May 4, 2016

SUBJECT: **Request for Modification of the Section 404 Individual Permit, Section 401 Water Quality Certification, Isolated Waters State General Permit, and Neuse River Riparian Buffer Certification** for the proposed East End Connector from NC 147 (Durham Freeway/Buck Dean Expressway) to north of NC 98 (Holloway Street) in Durham, Durham County, North Carolina, Division 5. Federal Aid Project No. NHF-76-1(2), TIP No. U-0071.

The purpose of this letter is to request a modification to the United States Army Corps of Engineers (USACE) Section 404 Individual Permit and North Carolina Division of Water Resources (NCDWR) Section 401 Water Quality Certification, Isolated Waters State General Permit, and Neuse River Riparian Buffer Certification for the above-referenced project.

In addition to this cover letter, please find enclosed revised Wetland Permit Drawing Sheet Nos. 30, 53, 55, 60, 90, and 91 of 91; revised Buffer Permit Drawing Sheet Nos. 6, 16, and 18 of 18; new ABF Freight Wetland Permit Drawing Sheet Nos. 1 and 2 of 2 for new Site No. 33, which is associated with the loss of property remediation between the N.C. Department of Transportation (NCDOT) and ABF Freig

SITE 4

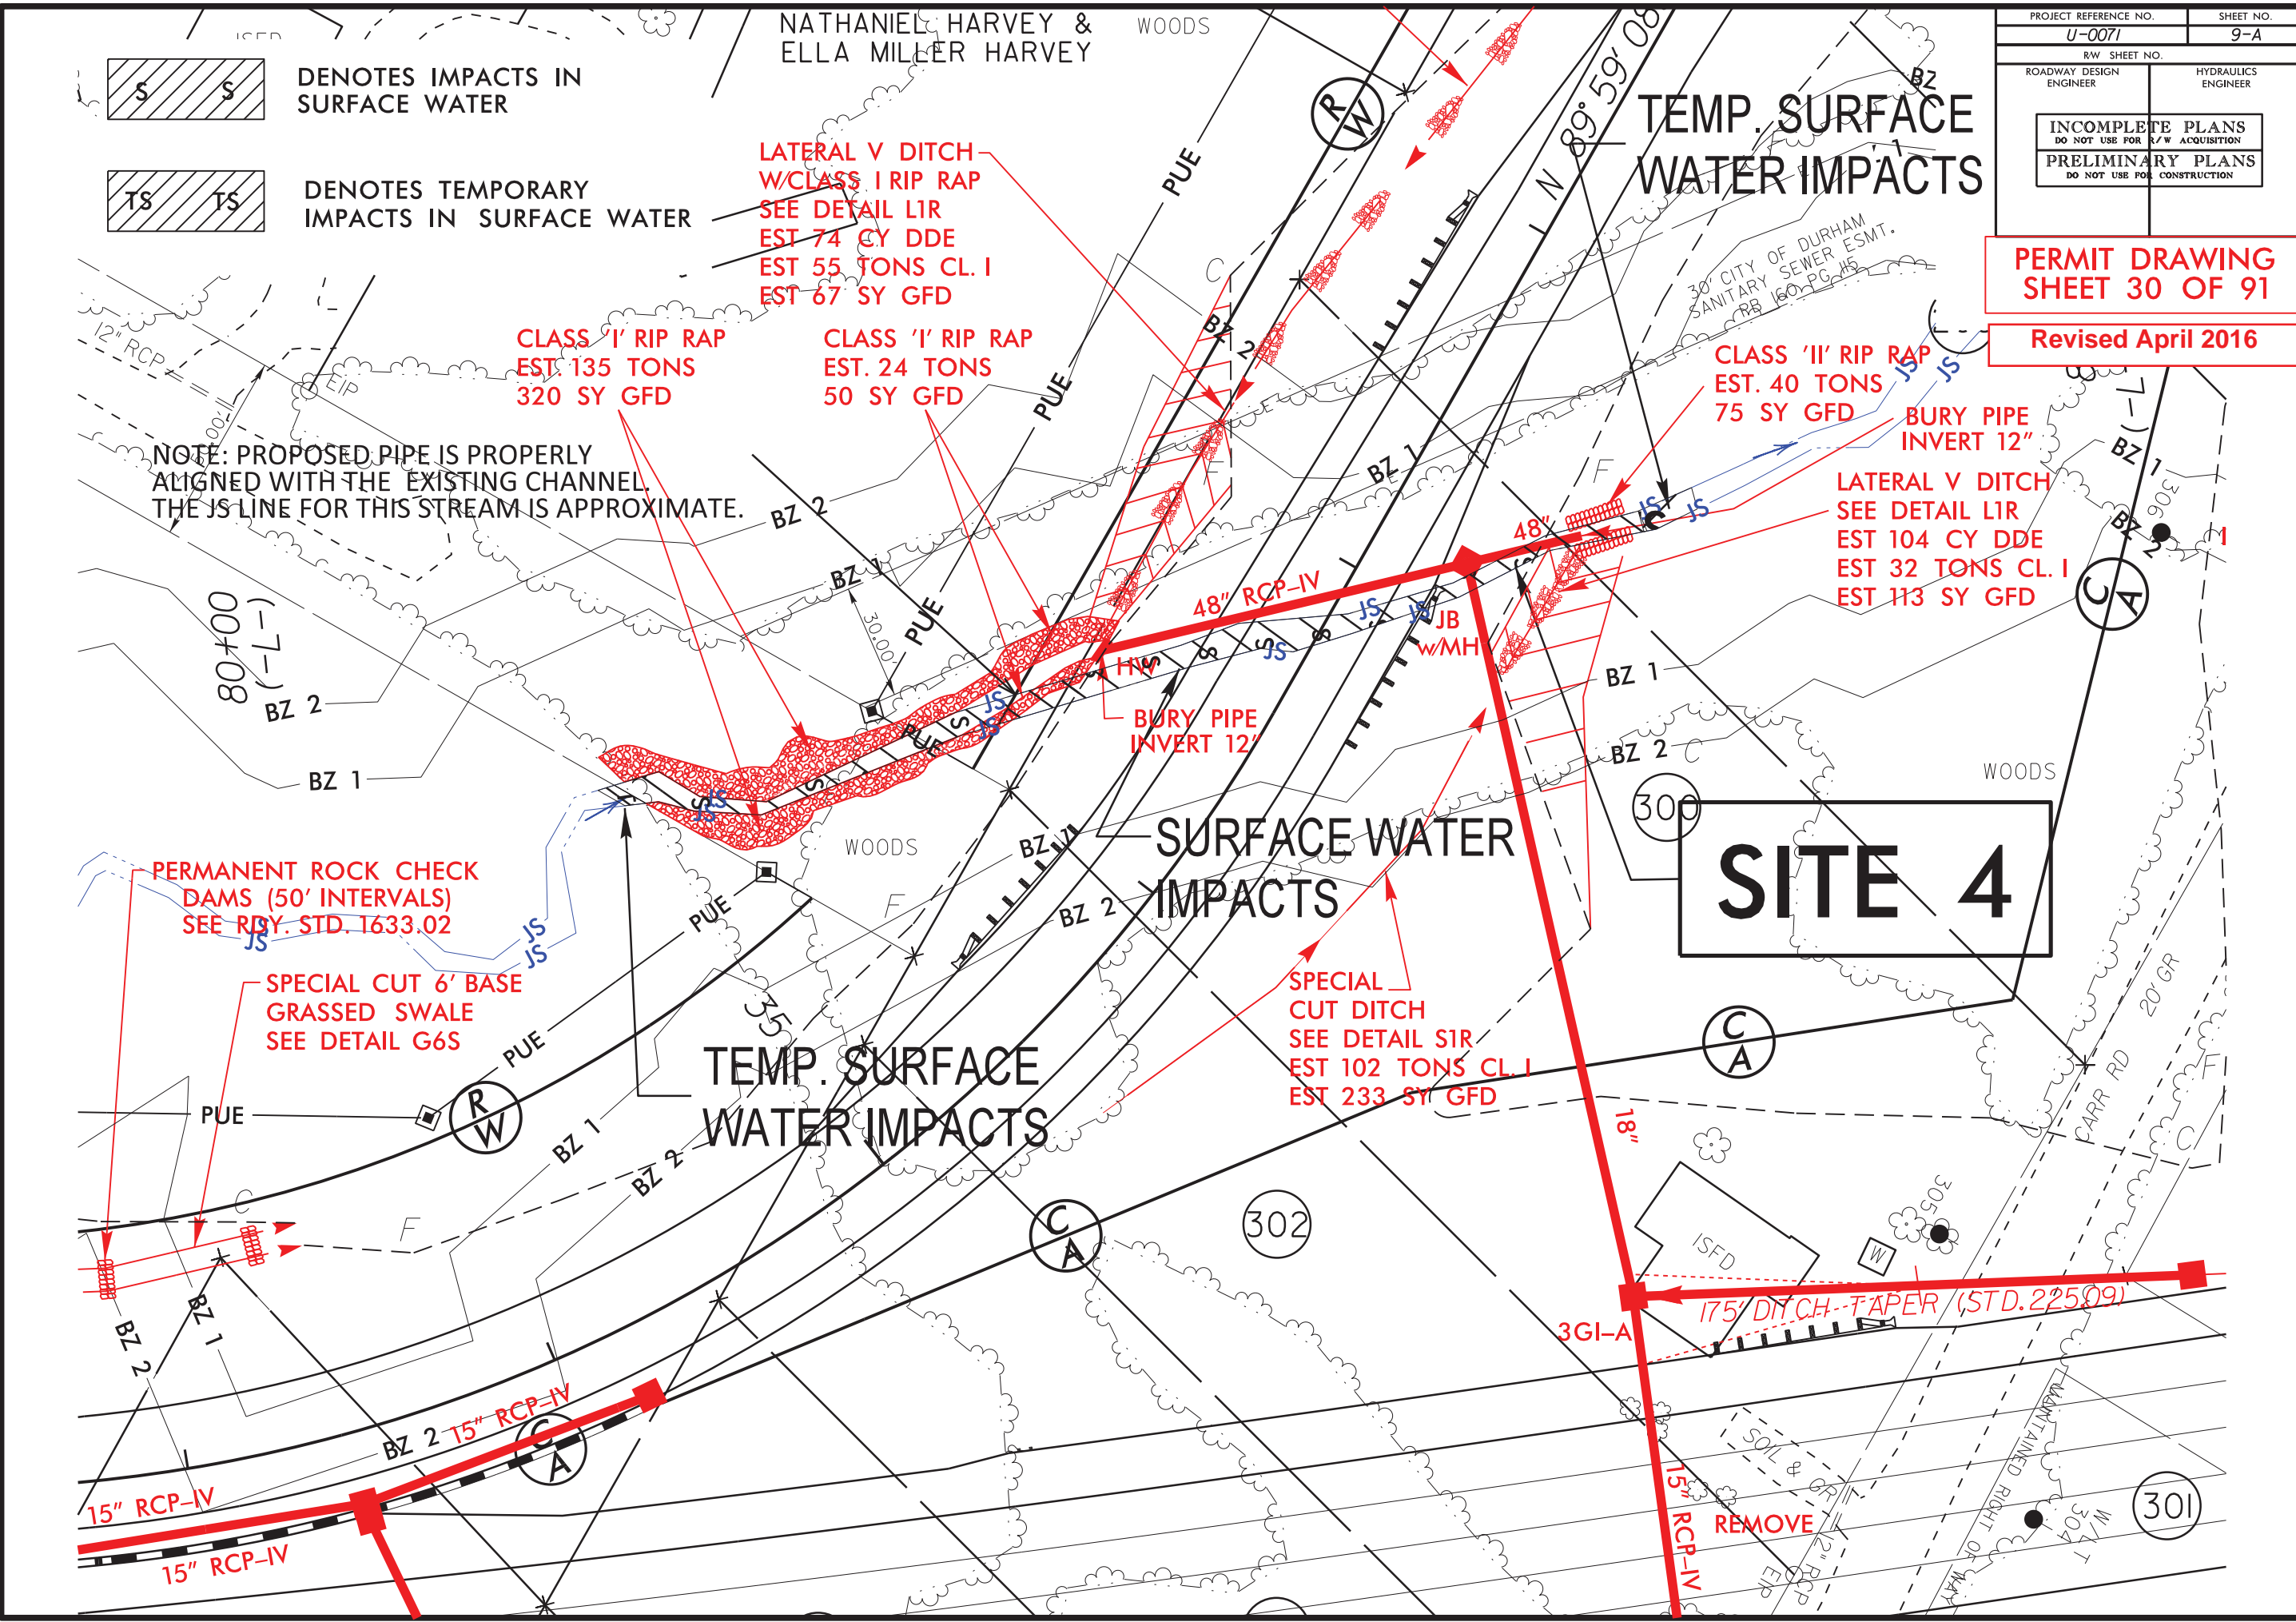
Permit Site 4 (Permit Drawing 30 of 91) at 36+20 -SR2- Lt

- The contractor has installed the 48-inch pipe structure and rip rap bank stabilization following the most recently approved permit drawing at this site. Recent rain events have resulted in significant scour and failure of streambanks immediately upstream of the rip rap that has been installed by the contractor. The Department proposes to install additional Class II rip rap on the stream banks that would allow for the permanent stabilization within the project limits.
- This design change will result in an increase in temporary stream impacts of 5 linear feet and an increase in permanent bank stabilization impacts of 105 linear feet.

SITE 12

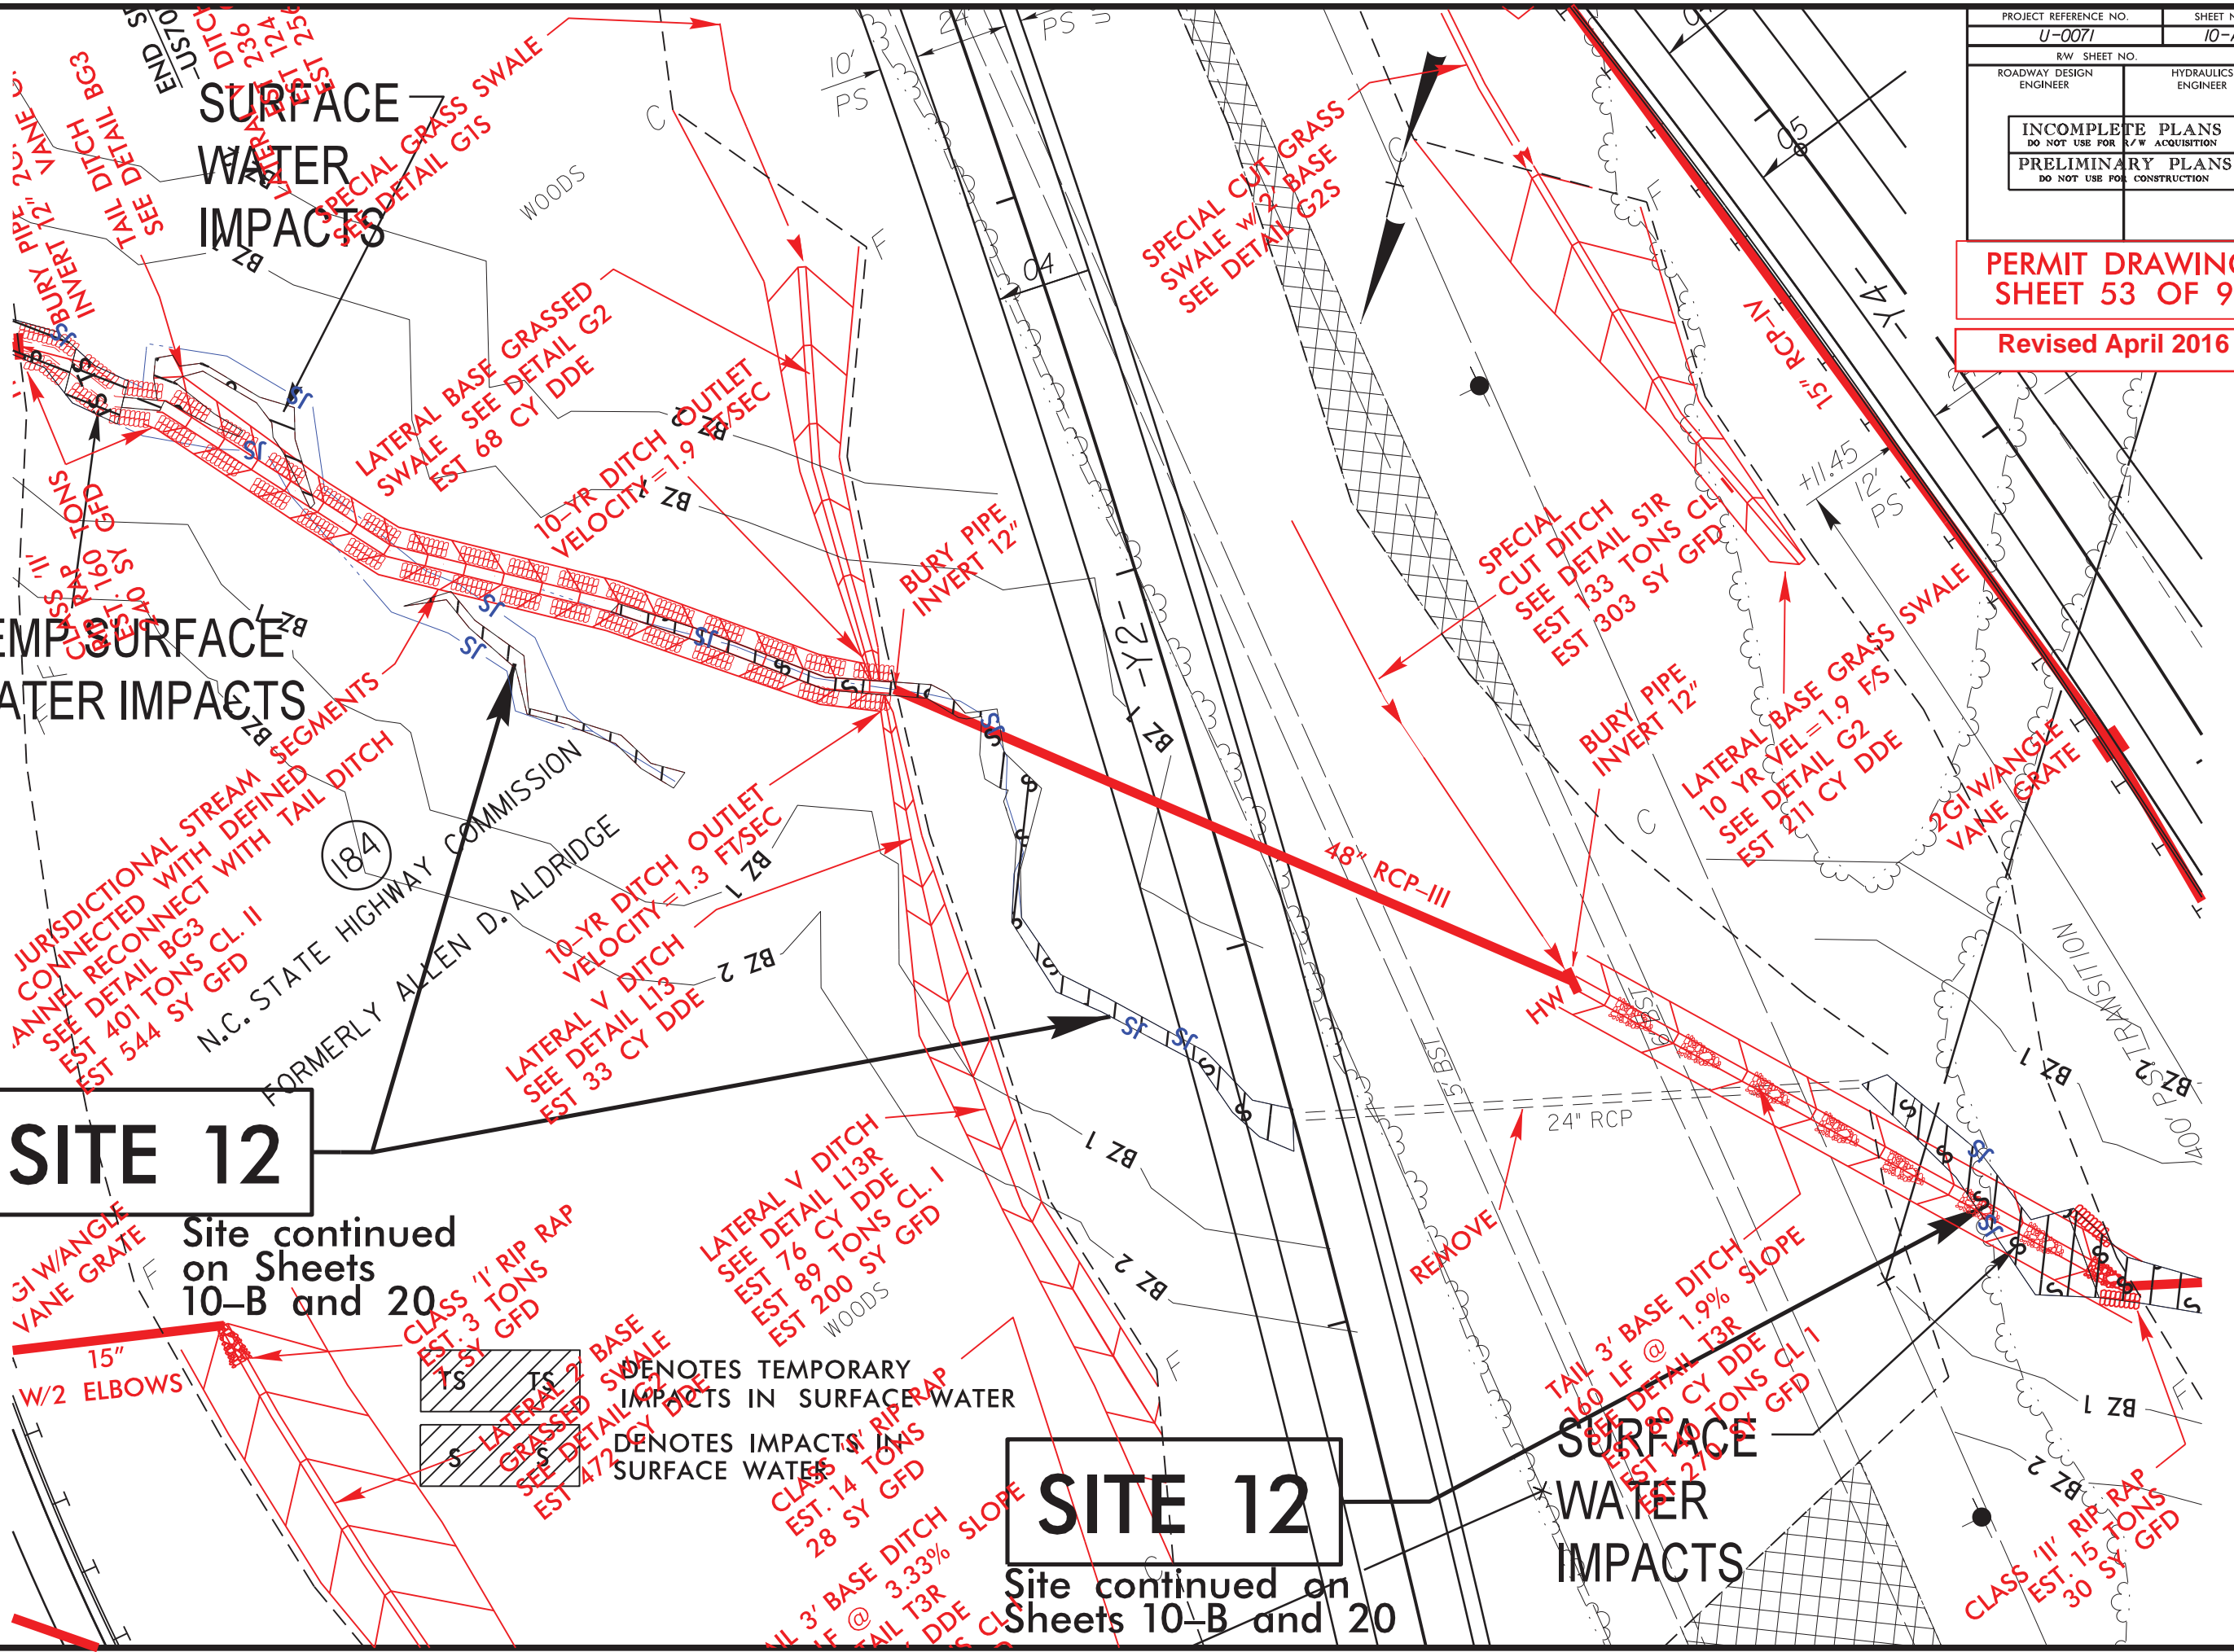
Permit Site 12 (Permit Drawing 53 of 91 and 55 of 91) at 25+50 -Y2- Rt

- Installation of the complete hydraulic system will result in an increase in runoff velocity during heavy rain events at this location. The Department has evaluated the existing stream channel and determined that the channel should be lined with a rip rap-lined 3 foot-base ditch to provide long-term stability.
- This design change will result in a decrease in temporary stream impacts of 60 linear feet, an increase of permanent stream loss impacts of 84 linear feet, and a decrease in permanent bank stabilization impacts of 24 linear feet.
